Council Reference: PL/176/2014/A

Location: Hunter Sports High School, 2 Pacific Highway, GATESHEAD NSW 2290

Proposed Use High School Redevelopment - Demolish and Rebuild entire school (minus existing MPC Dome)

Figure 26 – Proposed car parking layout

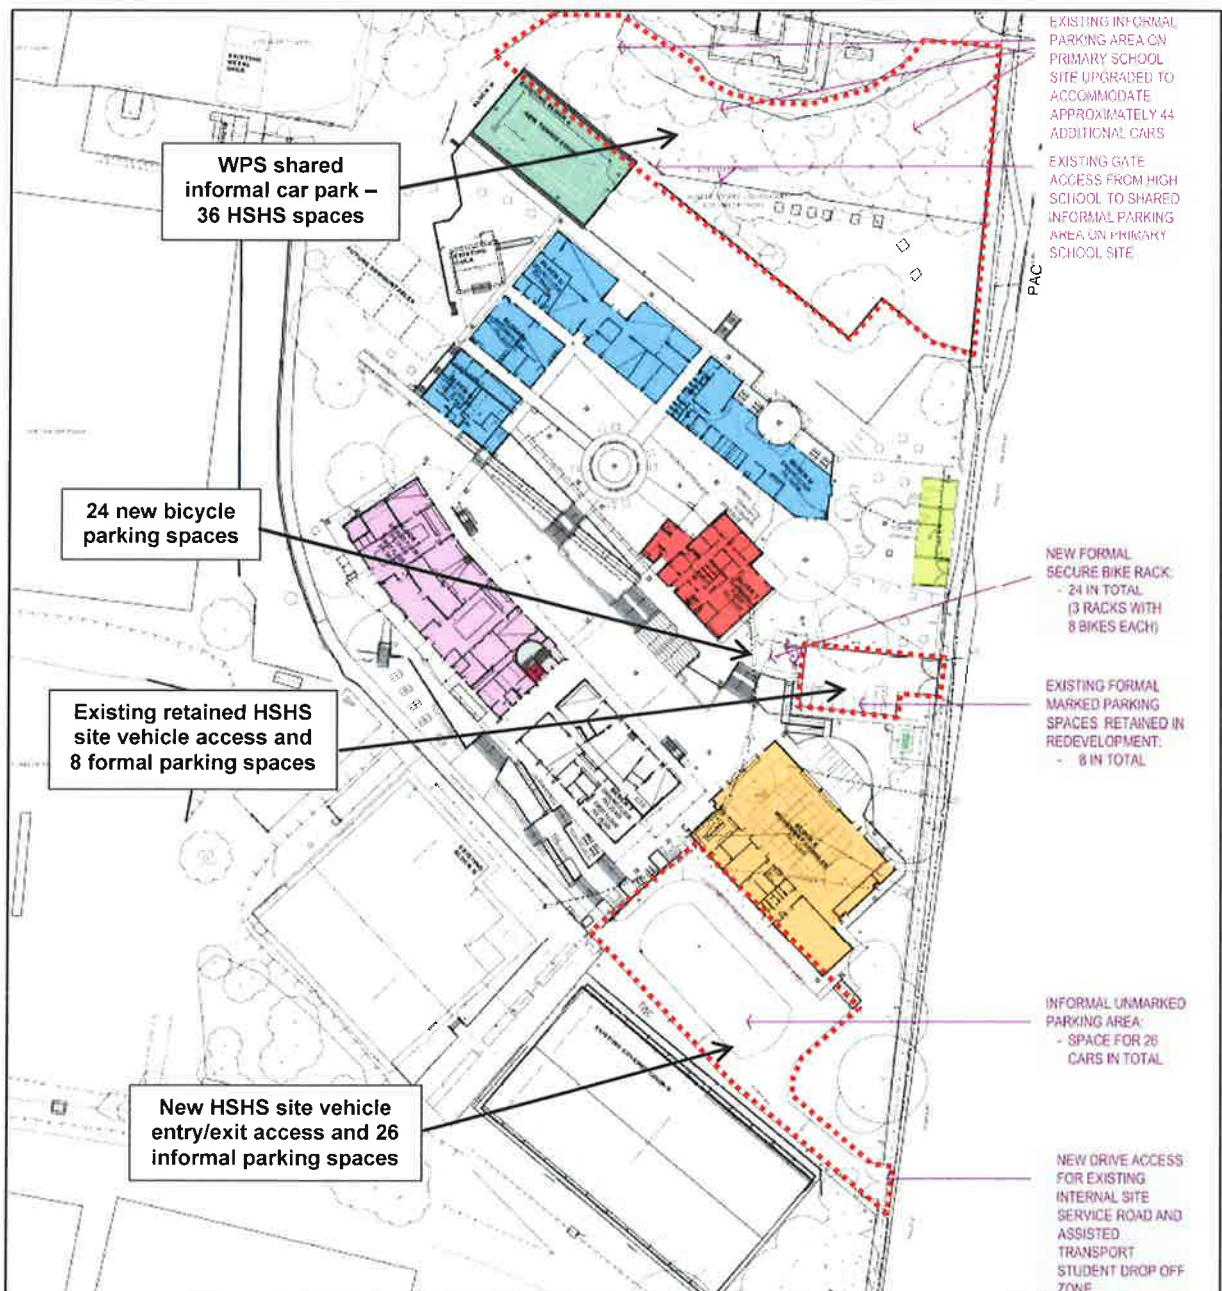
- Council's Traffic Engineer noted that upon her site inspection, 96 vehicles were observed to be parked on site in the existing car parks. The plans show 52 parking spaces are proposed. The proponent advised that there is an existing "informal" arrangement for overflow parking on the school site and it was discussed that consideration and detail of this should be included in the documentation submitted with the DA.
